Our Ref: EN010141/DR/8.1

Application Reference: EN010141

Applicant response to Planning Inspectorate section 51 advice following decision to accept the application for Examination

Figure 8c: Flood Map for Planning Flood  
Zones plus Climate Change for 2080s  
epoch (Grid Connection)

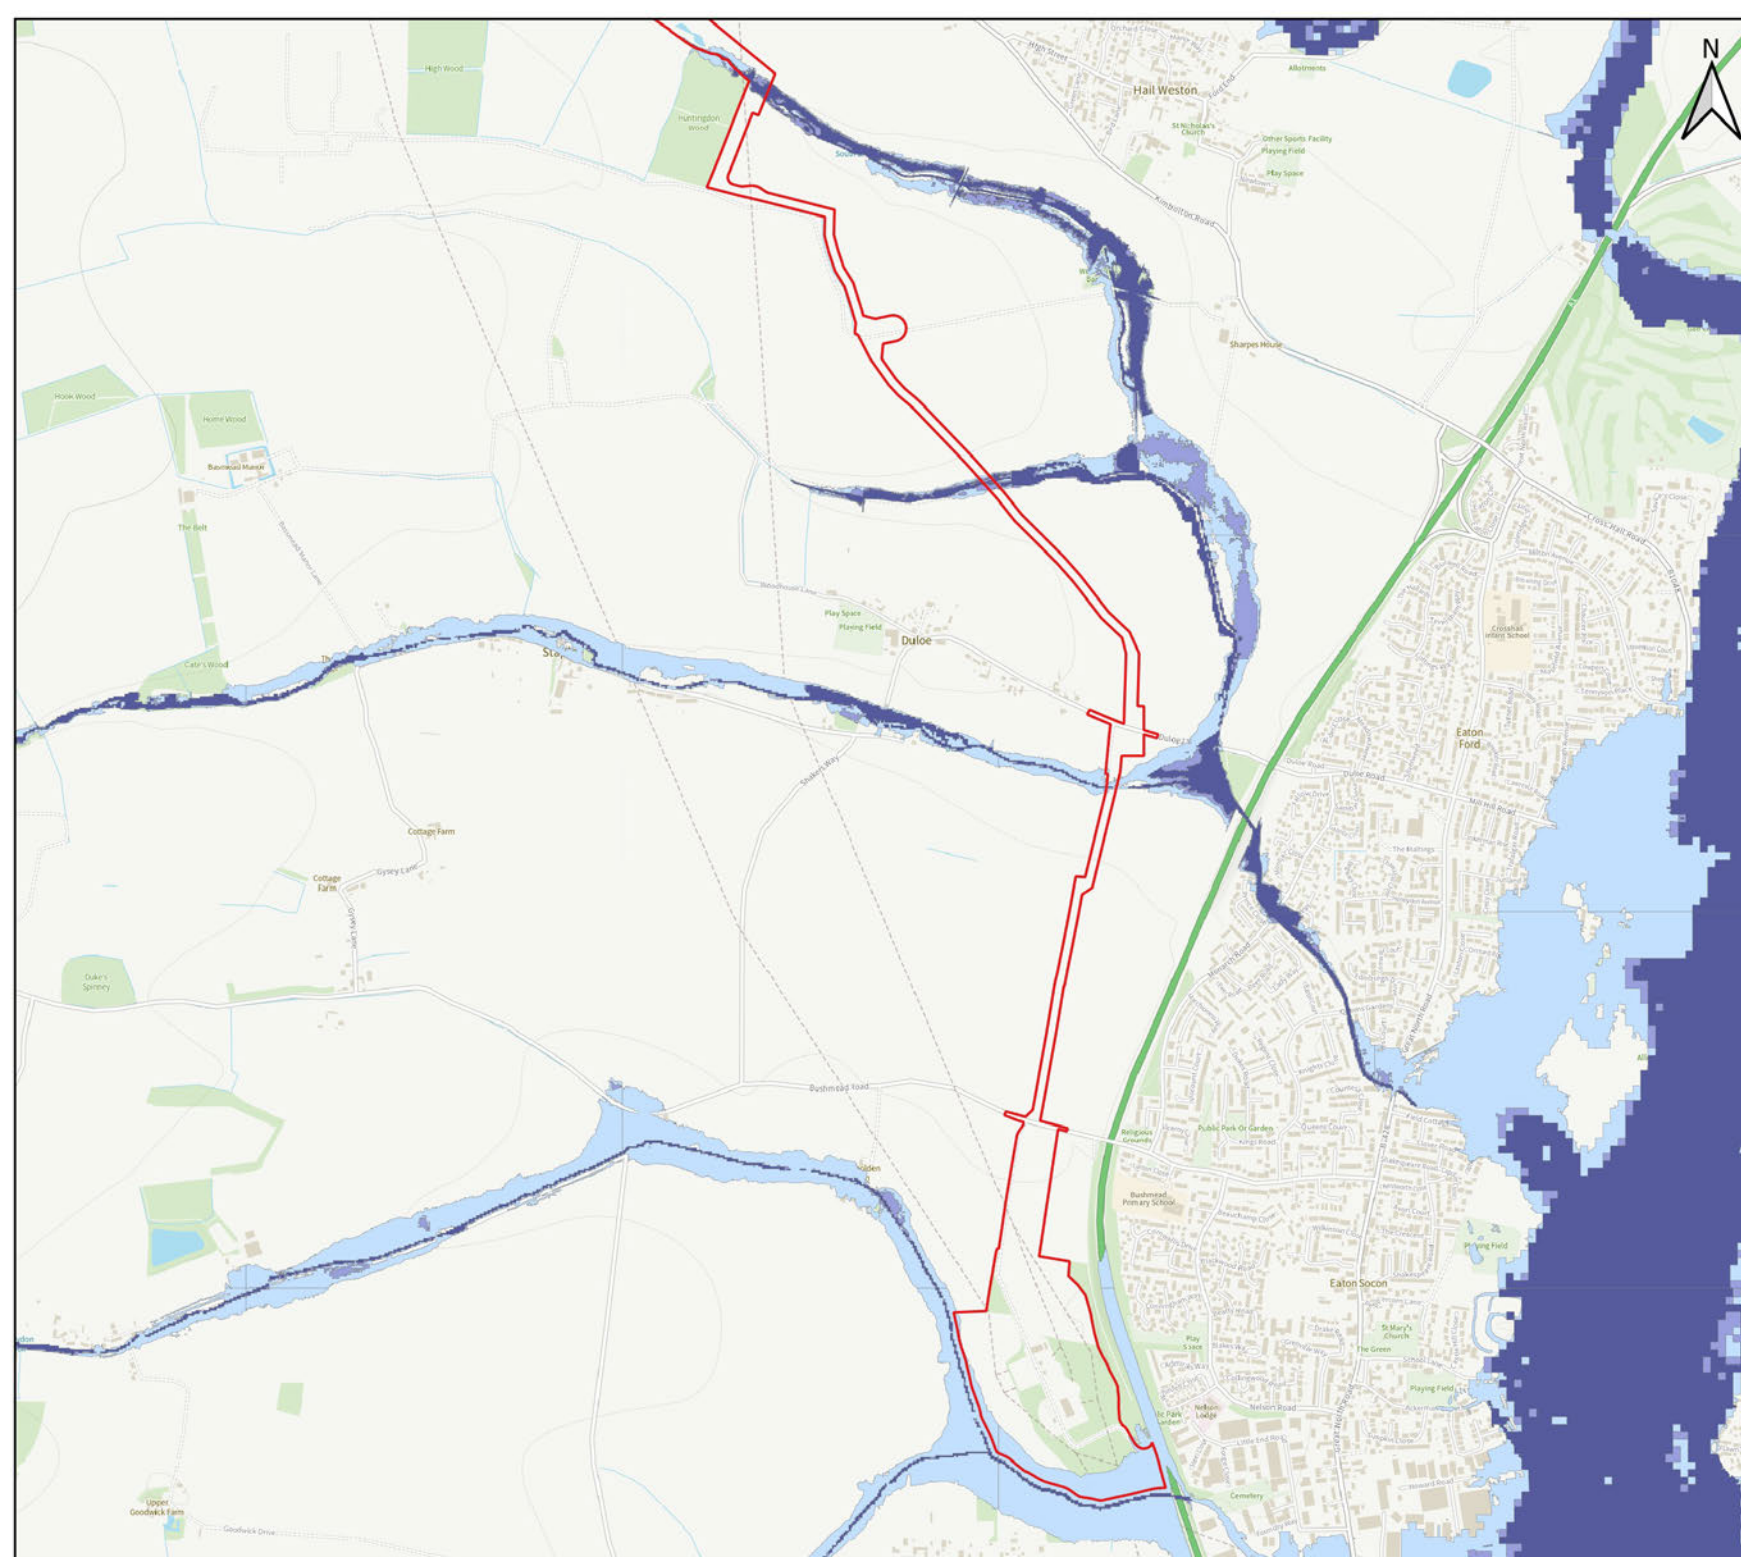
Figures 7a, 7b, 7c, and Figures 8a, 8b, and 8c of the FRA show the maps with RoFRS and RoFSW with climate change allowances for the 2050s epoch although the proposed development is anticipated to have a lifetime of 40 years up to 2070. The applicant to provide revised figures to show RoFRS and RoFSW with climate change allowances up to the 2070s epoch should be sought.

2. The Applicant has now included additional figures (Figures 8a to 8c) within **ES Vol 2 Appendix 8-1: Flood Risk Assessment [EN010141/DR/6.2]** which illustrate the risk of flooding from rivers and the sea with climate change allowances for the '2070s epoch'. For the risk of flooding from surface water, there is no published dataset that provides the '2070s epoch'. The Applicant intends to consult further with the Environment Agency and Lead Local Flood Authorities on this matter to establish whether bespoke modelling of the 2070s epoch for surface water flood risk is necessary at this time, or whether it could be a matter for detailed design.
